DEVELOPMENT REVIEW BOARD

Code Enforcement Comments

DRB Project Number: 1001569

Application Number: 18DRB-70099

PLAT OF LOTS 1-A & 1-B, BLOCK 25 PARKLAND HILLS

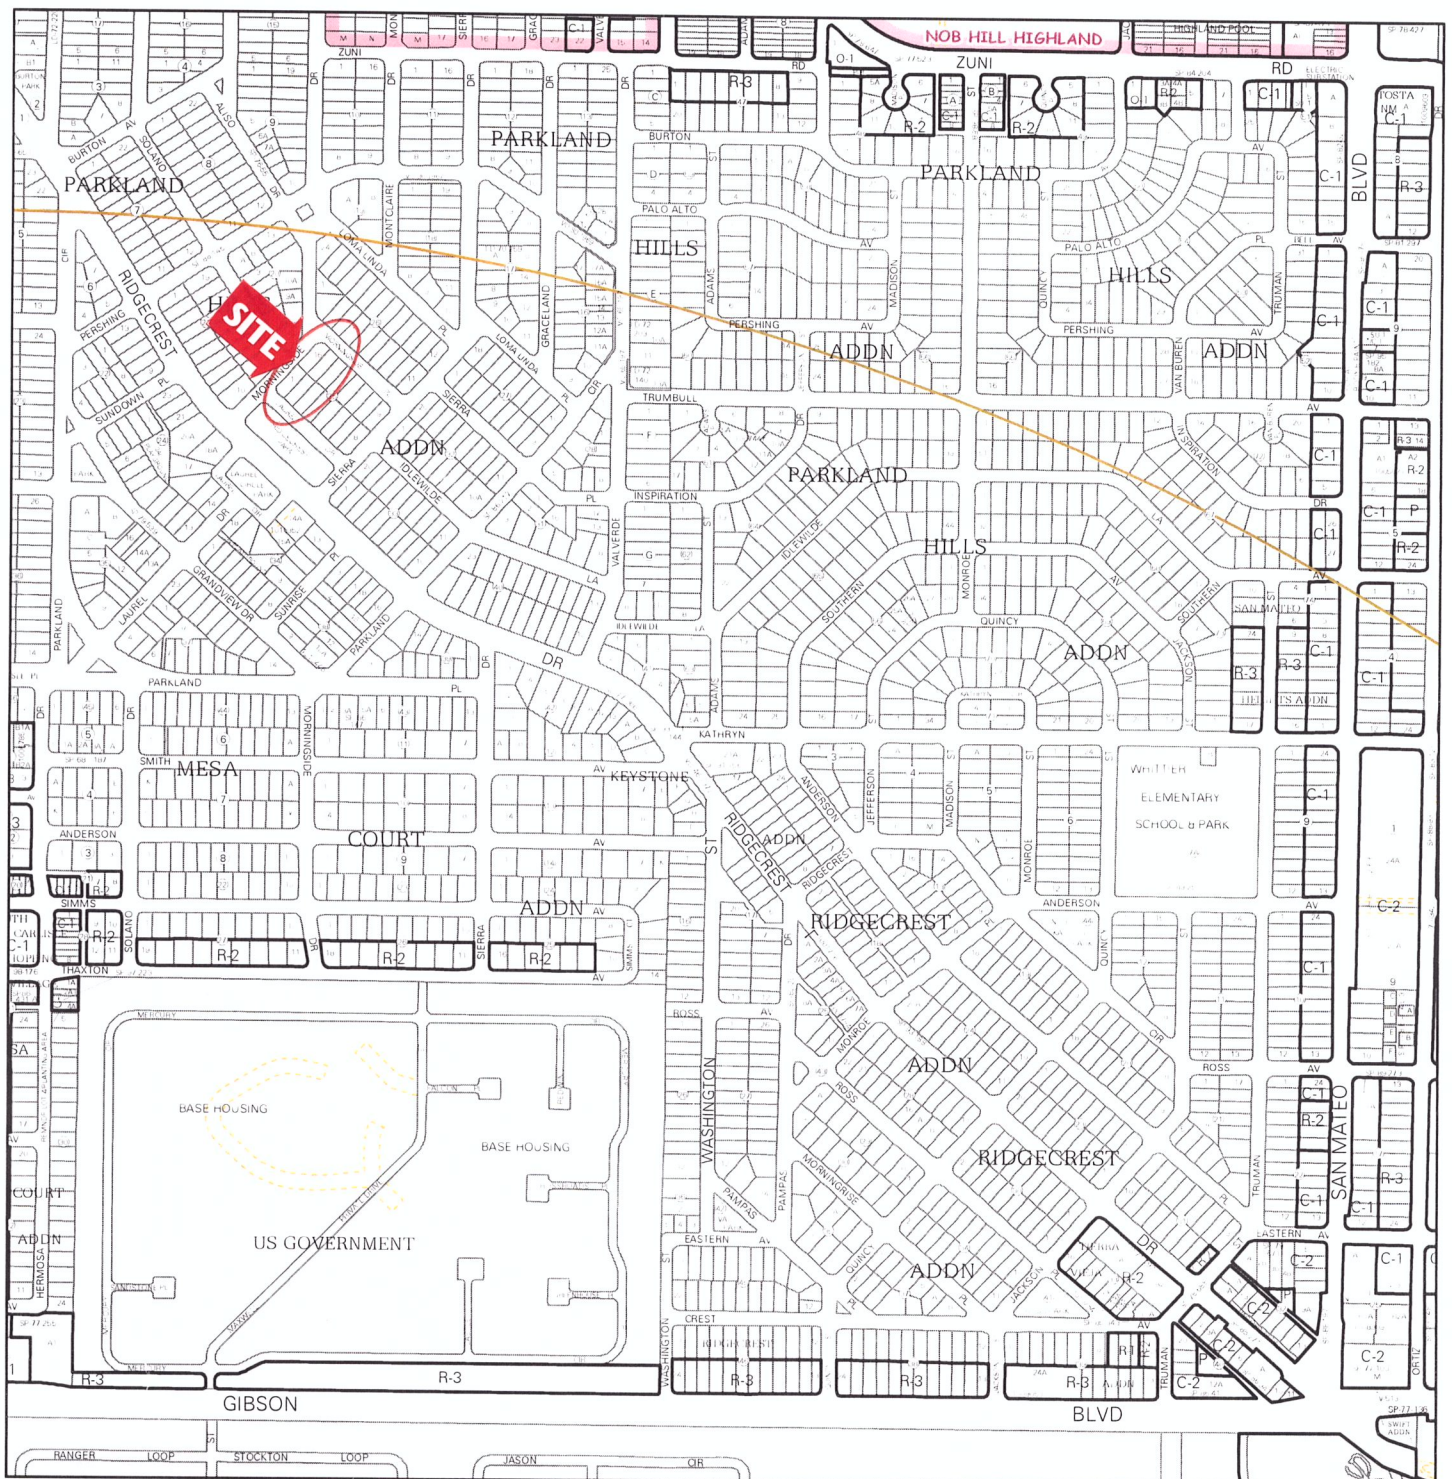
No objection to eliminating the lot line as lot size and rear yard setback of 15 feet requirements have been met.
